**CITY OF ALBUQUERQUE
ADMINISTRATIVE APPROVAL (AA)-
SITE DEVELOPMENT PLAN AMENDMENT TRACKING SHEET**

| APPLICATION #: SI-2020-00027 | PROJECT #: PR-2018-001346 |
| PROJECT NAME: Tin Can Alley | |

**RE: Project number BP-2018-001346, Mixed Use Development, Alameda & San Pedro NE,
specifically Tin Can Alley, 6110 Alameda NE**

2 | north elevation
A201 | 3/16" = 1'-0"

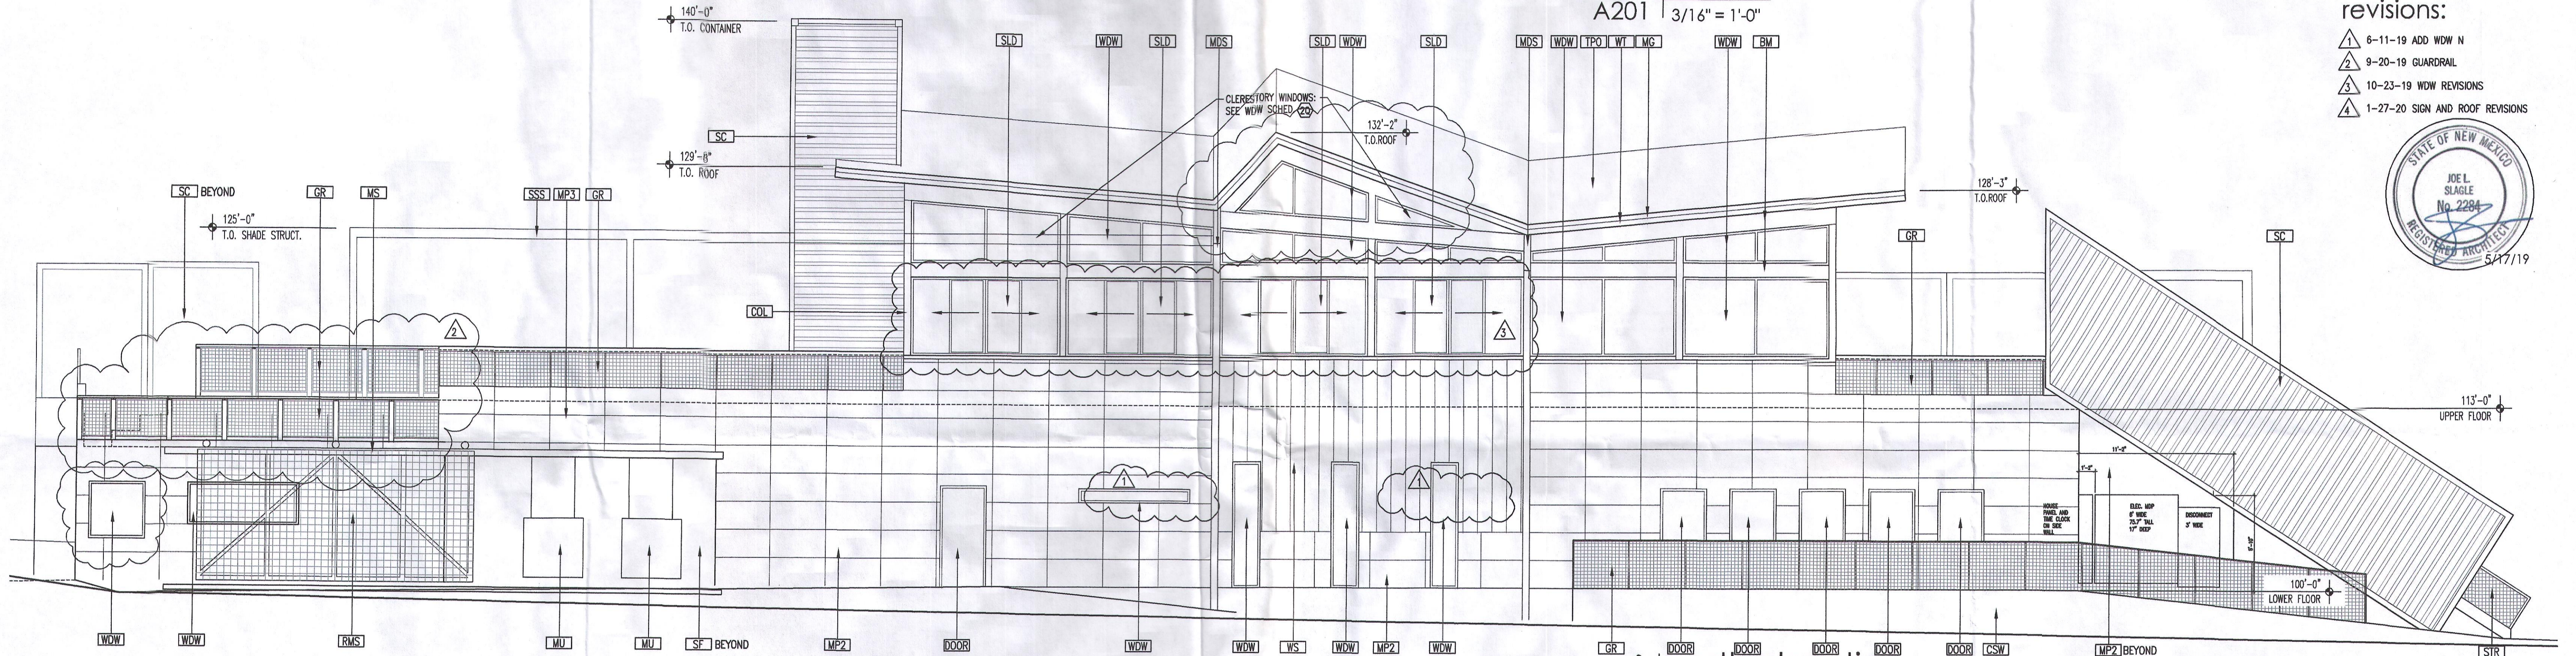
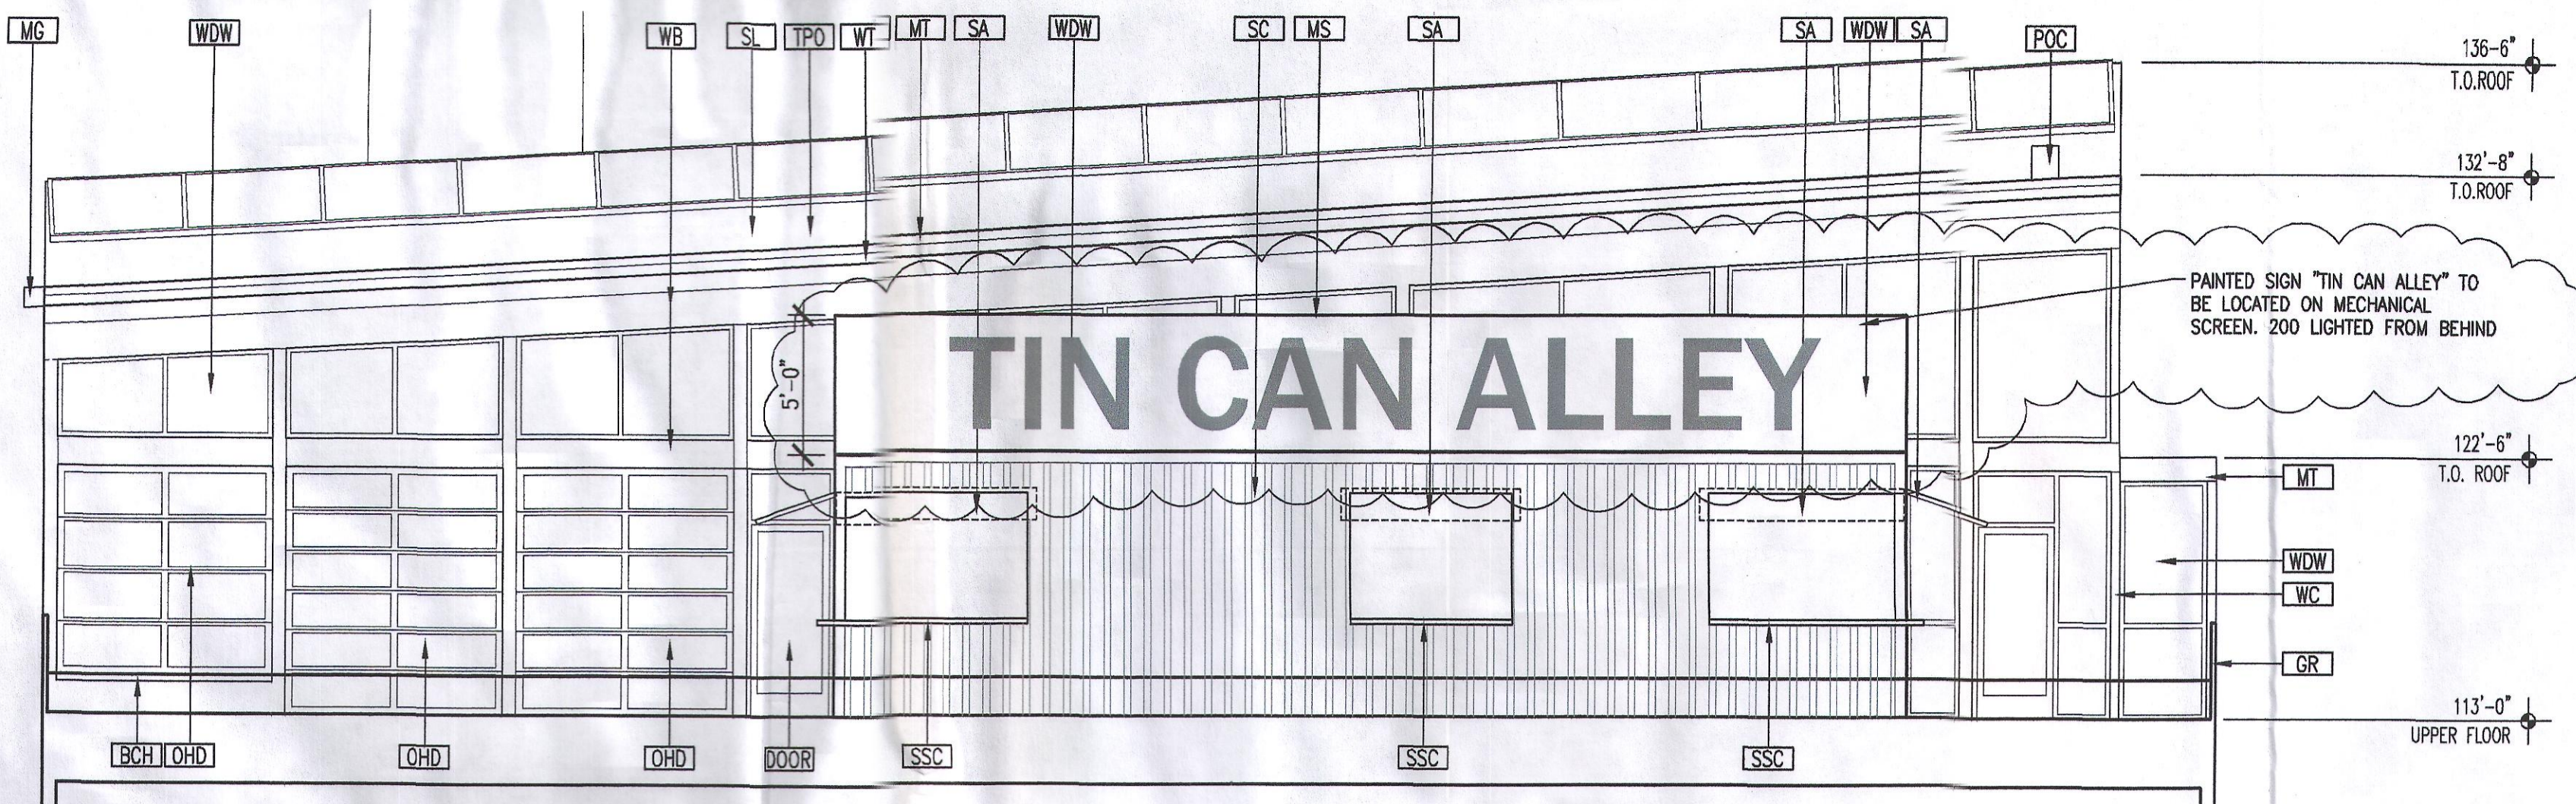
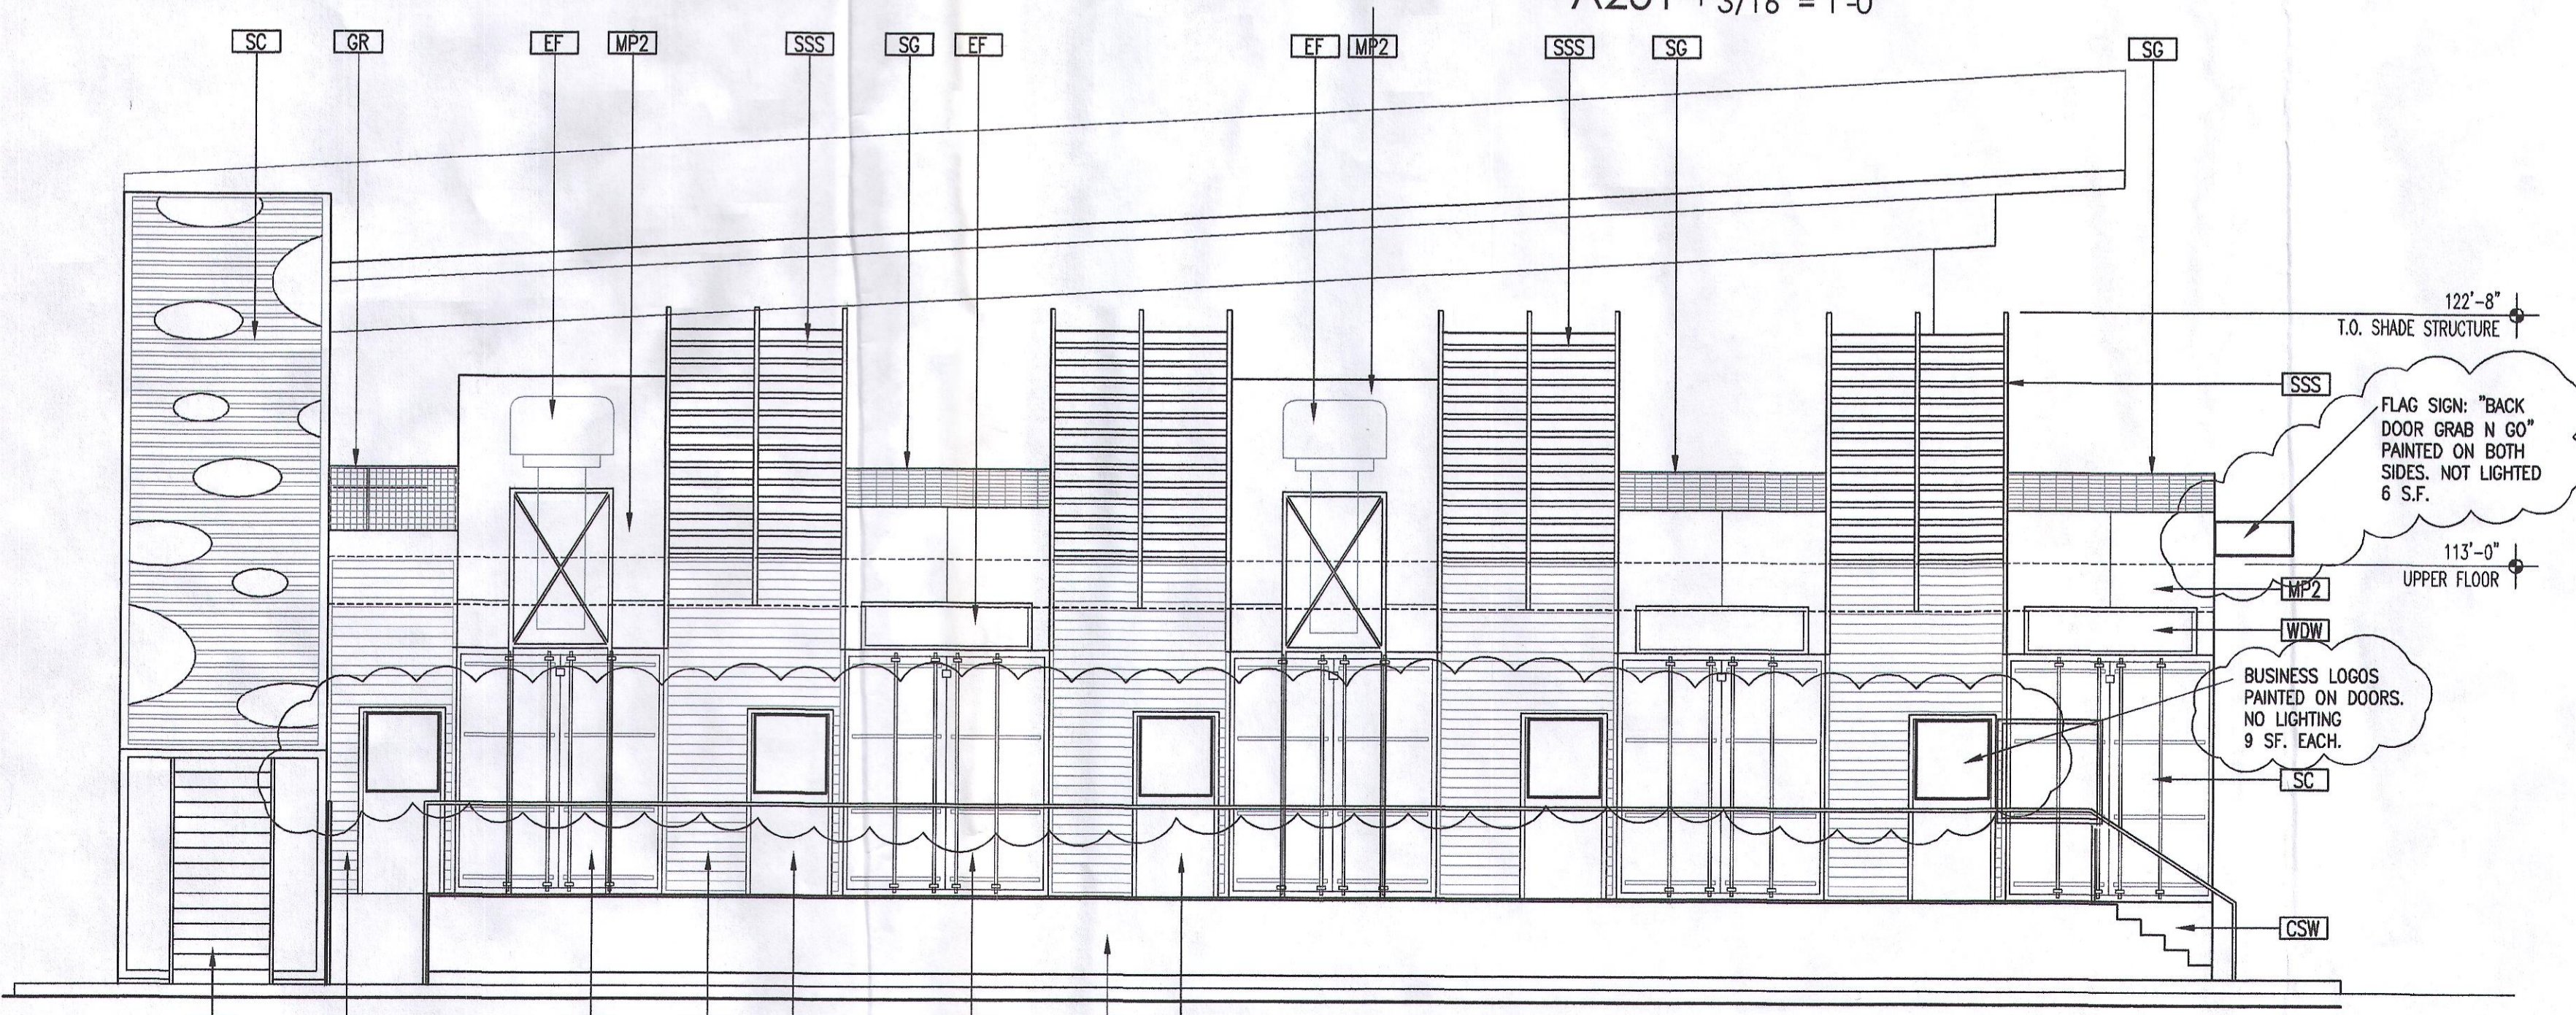
| Per sheet A201: | |
| 1. New roof line w/skylights | |
| 2. New signage | |

1. The roof line has been modified from the approved DRB elevations to include a ridge line with skylights as shown on the attached sheet A201
2. Additional signage is requested as shown on the attached elevation sheet A201.

1 | container development  
 building 2 north elevation  
 8 | 1/8" = 1'-0"

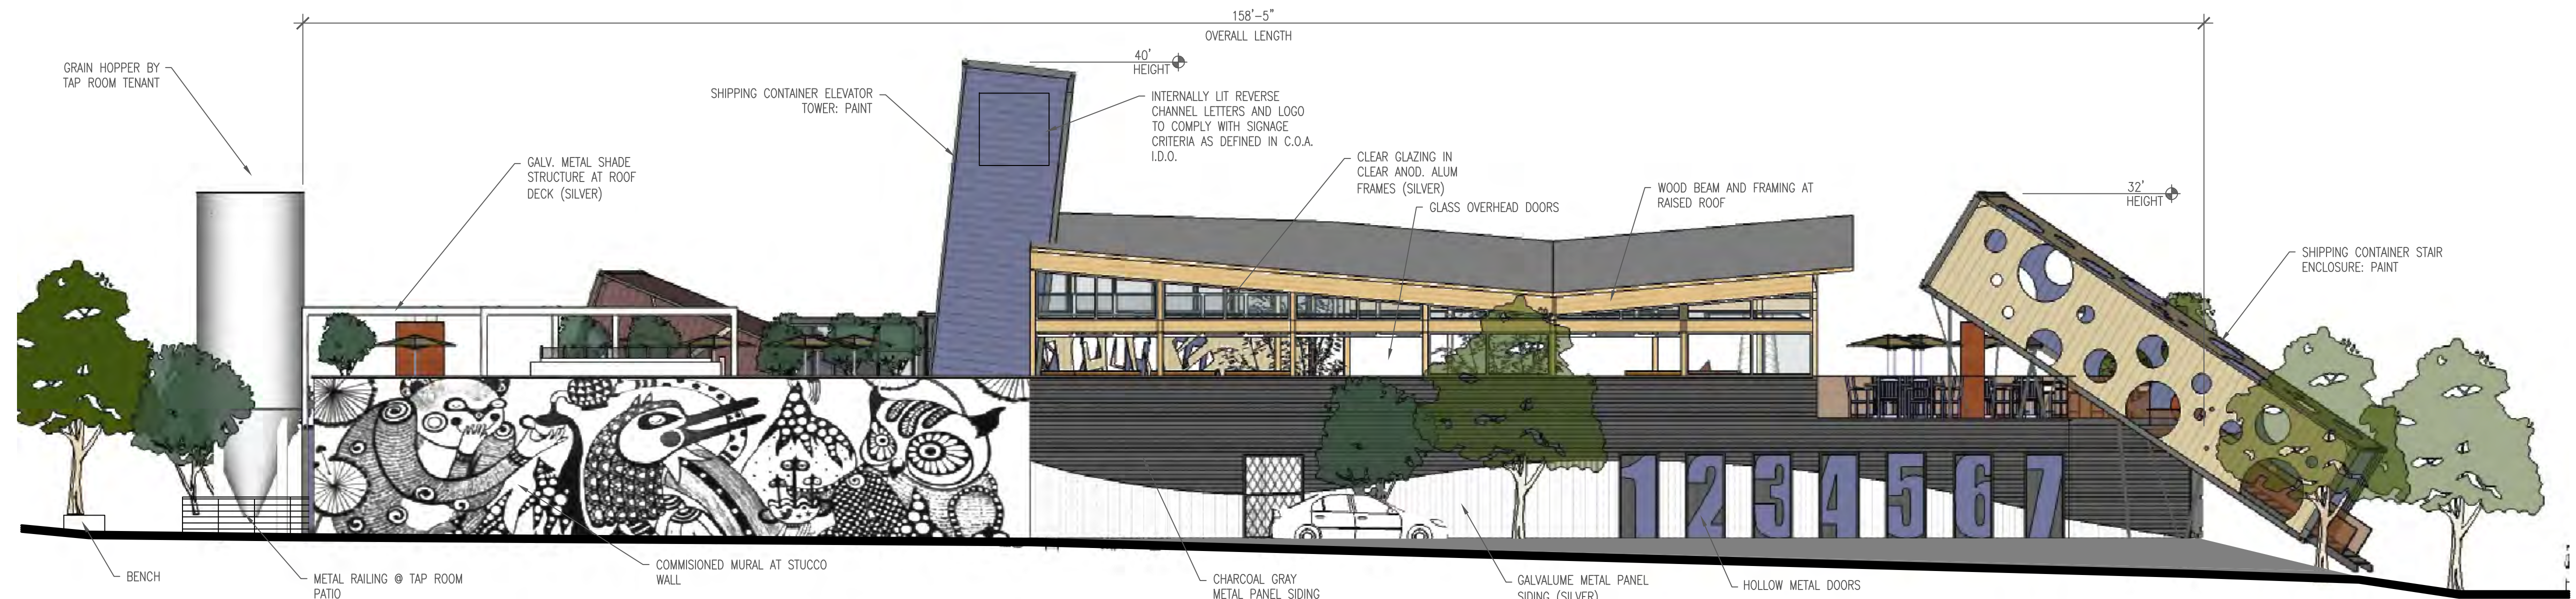
BRIEF DESCRIPTION OF REQUEST
 Administrative Amendment to approved site development to add signage and to update north elevation, because roof line has been revised.
